Loft conversion with proposed dormers to the front and rear

8 Langbury Close Ferring

Thank you for your internet representation made on 18th February 2019 which has been recorded as '**no objection**' with the comments as follows:

South Elevation

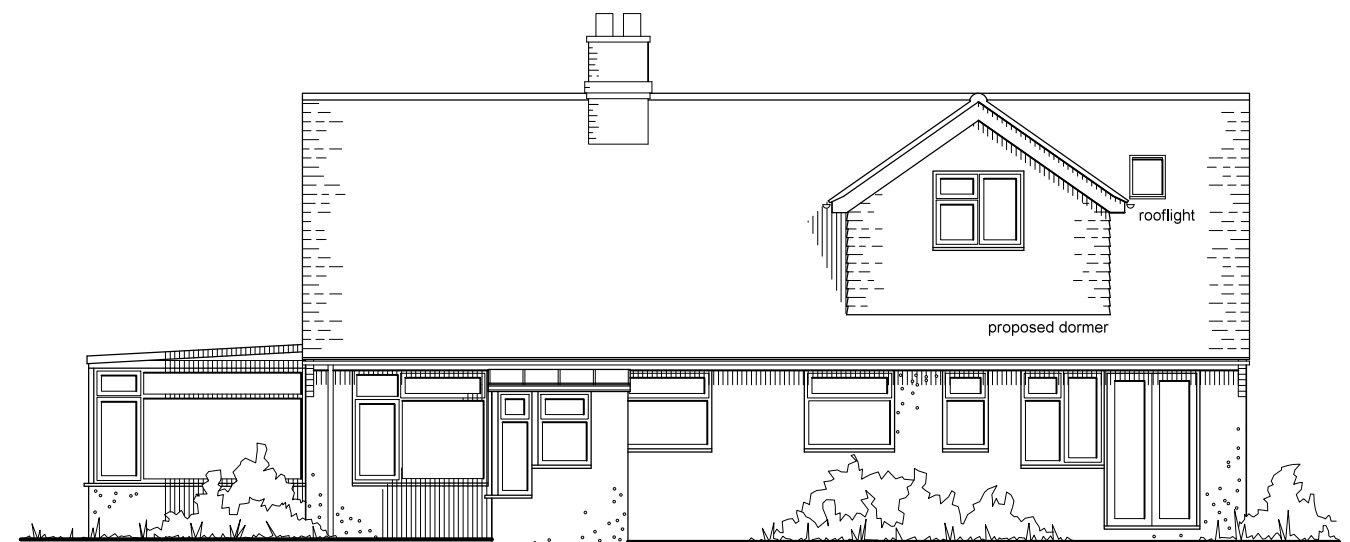
We request that any decision to grant this application incorporates a condition that glazing to the new south facing dormer window (in the new en suite room) is entirely of obscure glass, in order to prevent direct overlooking in to our rear garden.
